OXFORDSHIRE COUNTY COUNCIL'S RESPONSE TO CONSULTATION ON THE FOLLOWING DEVELOPMENT PROPOSAL

Application no: 21/03558/OUT

Proposal: OUTLINE - Residential development for up to 250 dwellings including affordable housing and ancillary uses including retained Local Wildlife Site, public open space, play areas, localised land remodelling, compensatory flood storage, structural planting and access.

Response date: 27th April 2022

TITLE
**DRAINAGE STRATEGY
 SHEET 2 (EASTERN DEVELOPMENT)**

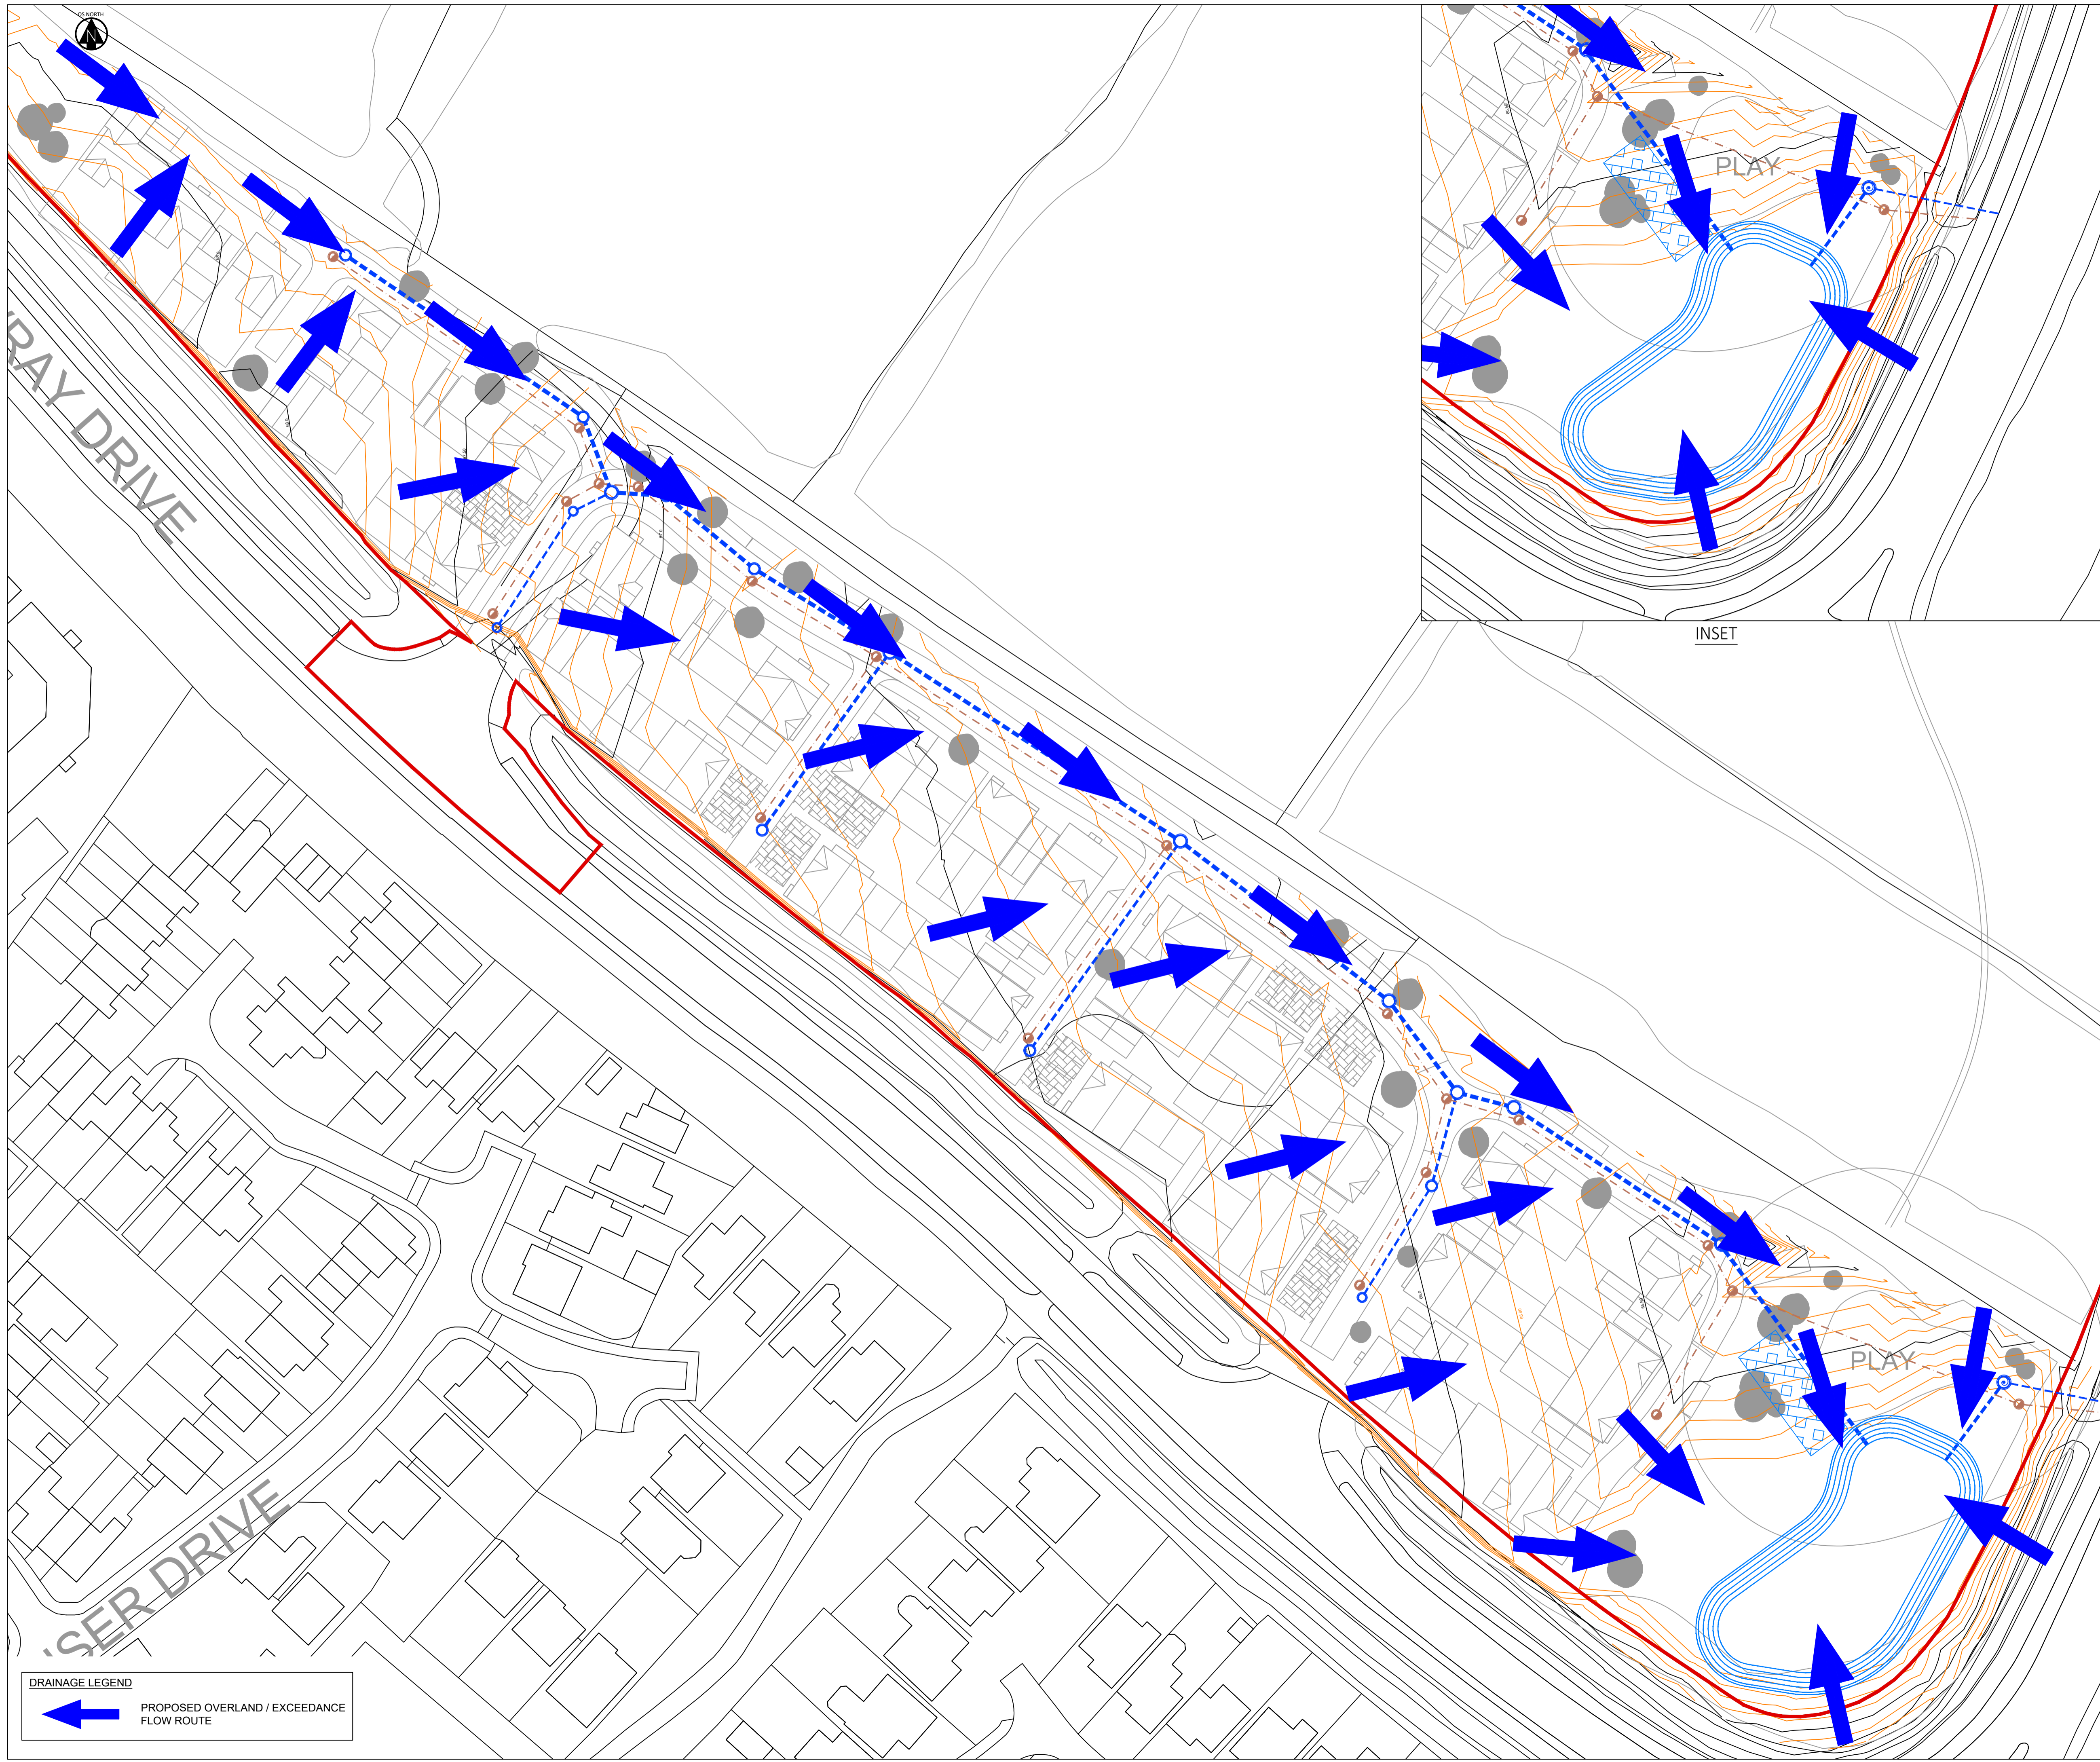
Basin 4 invert level is not consistent between the drainage plan and calculations.

TITLE
DRAINAGE STRATEGY
SHEET 1 (WESTERN DEVELOPMENT)

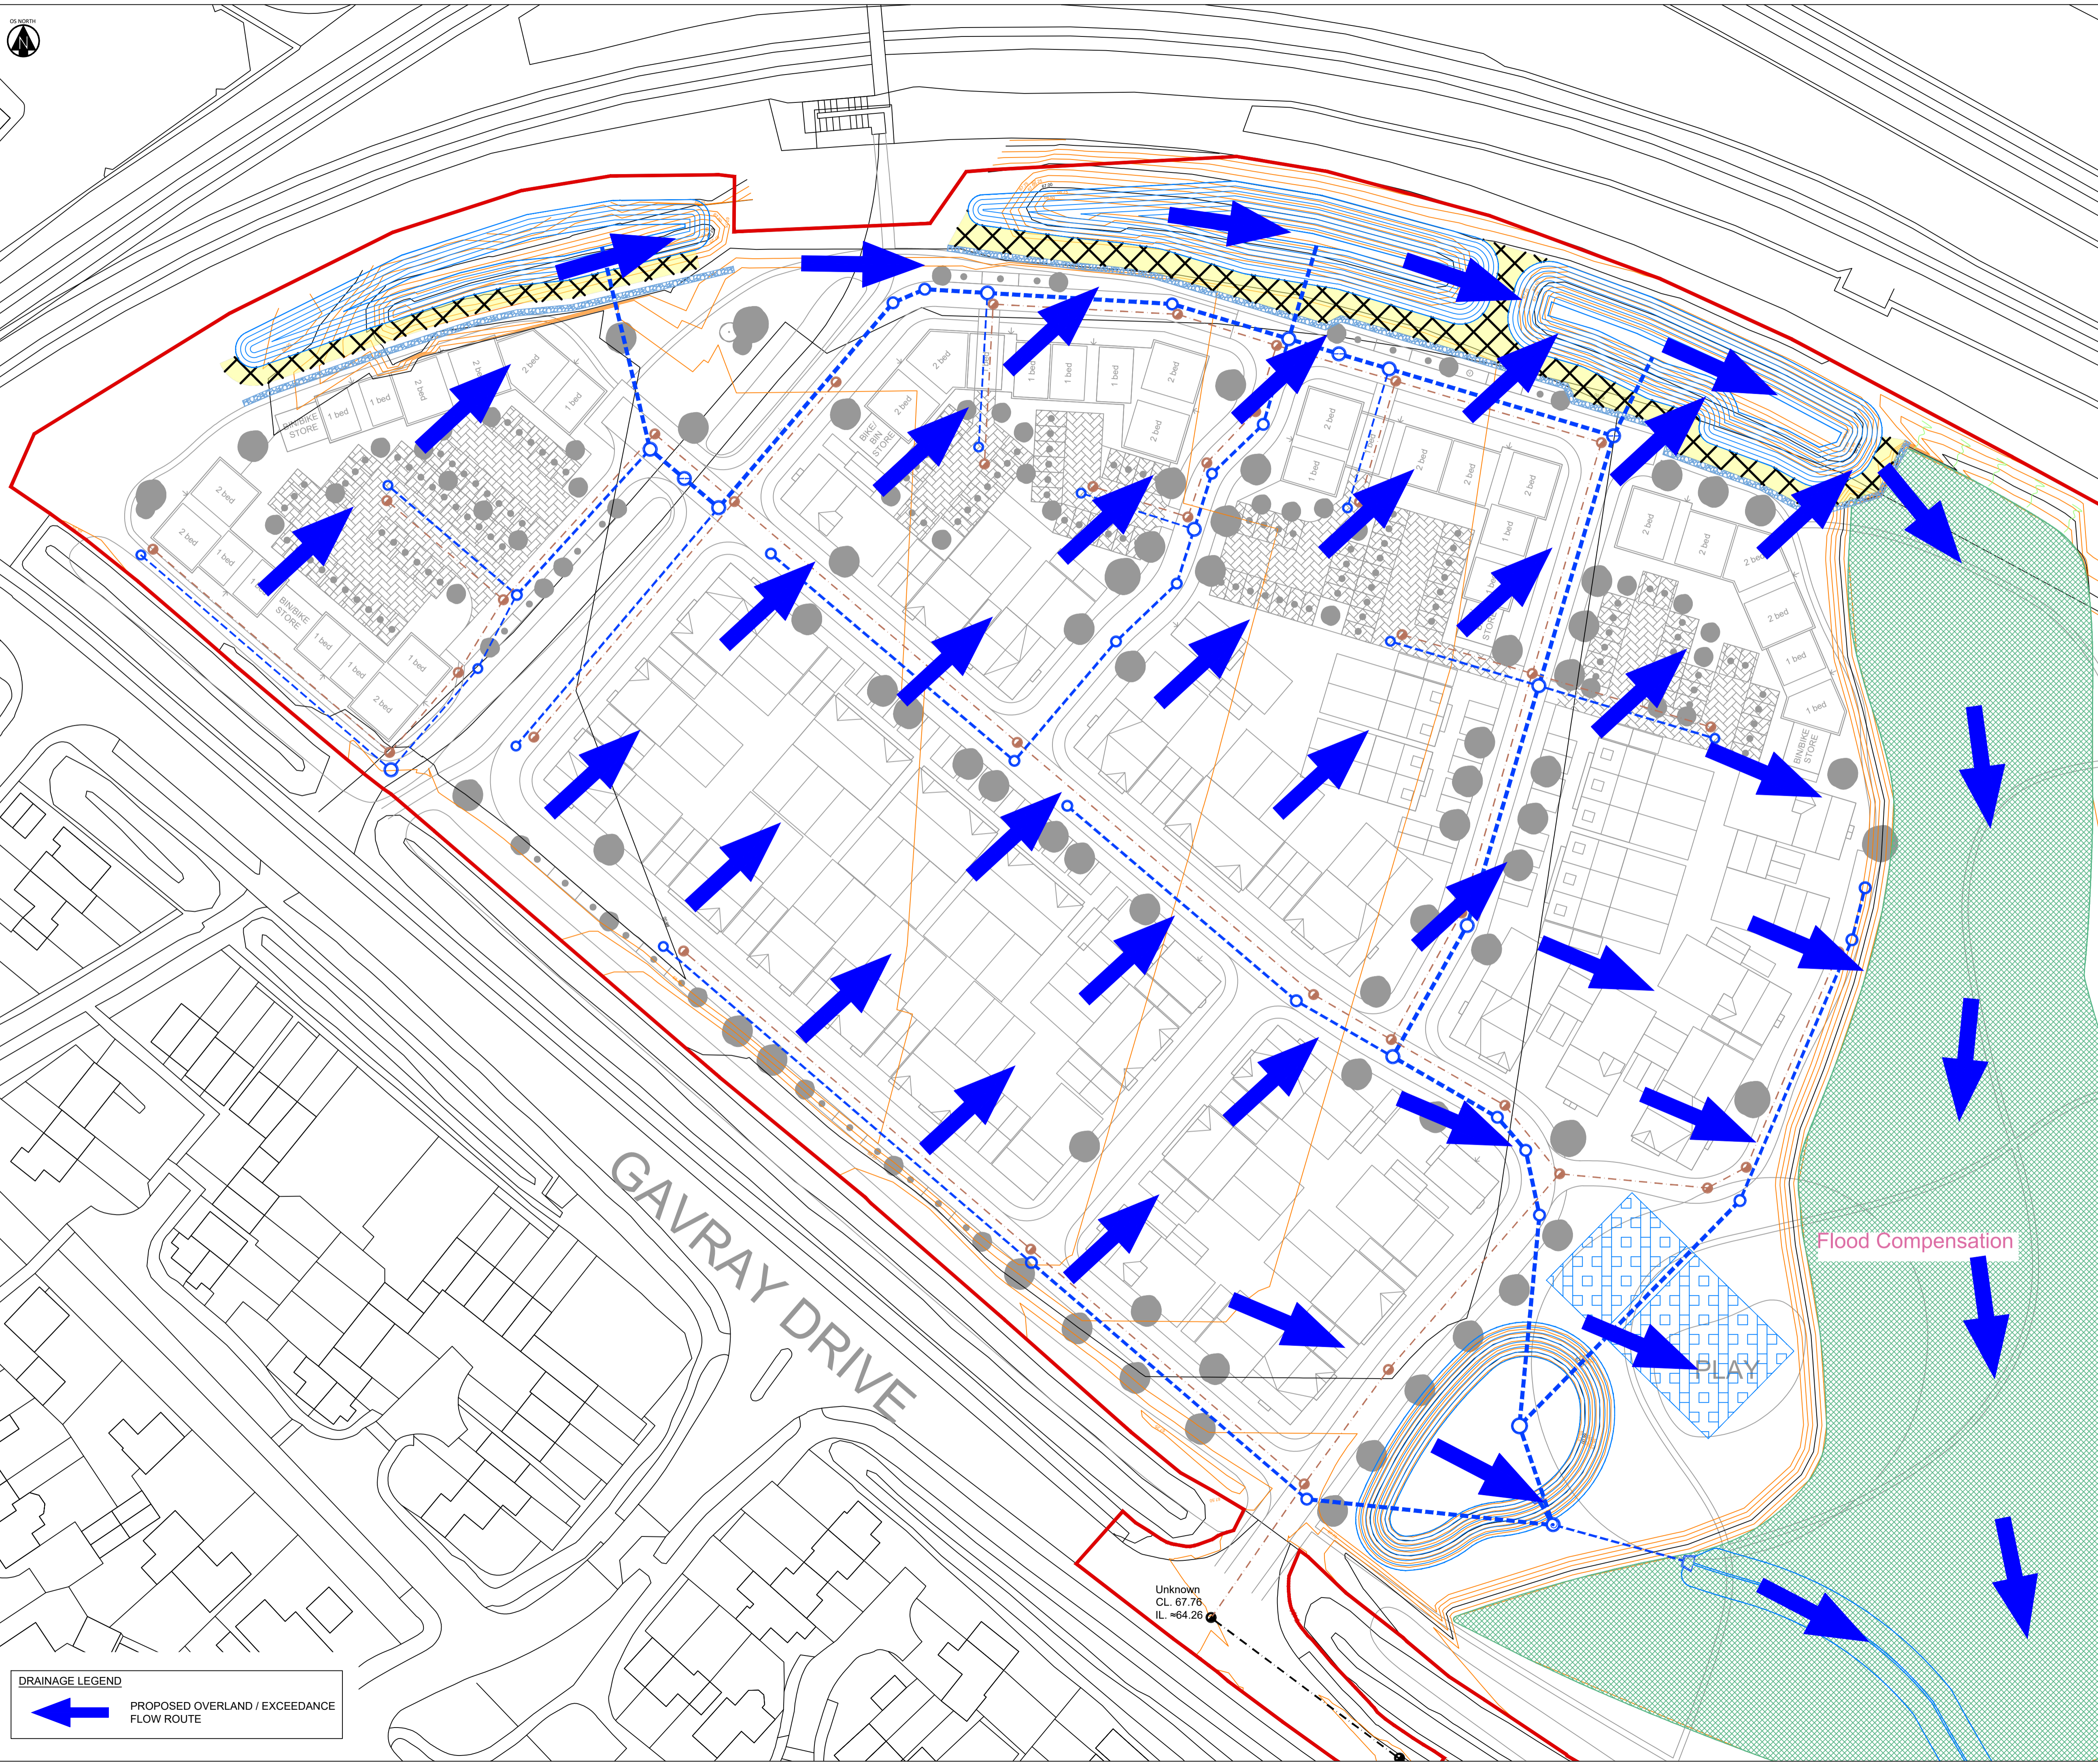
The outfall ditch on the drainage plan does not show where its leading to. Provide the whole extent of the ditch and where it will discharge to on the drainage plan.
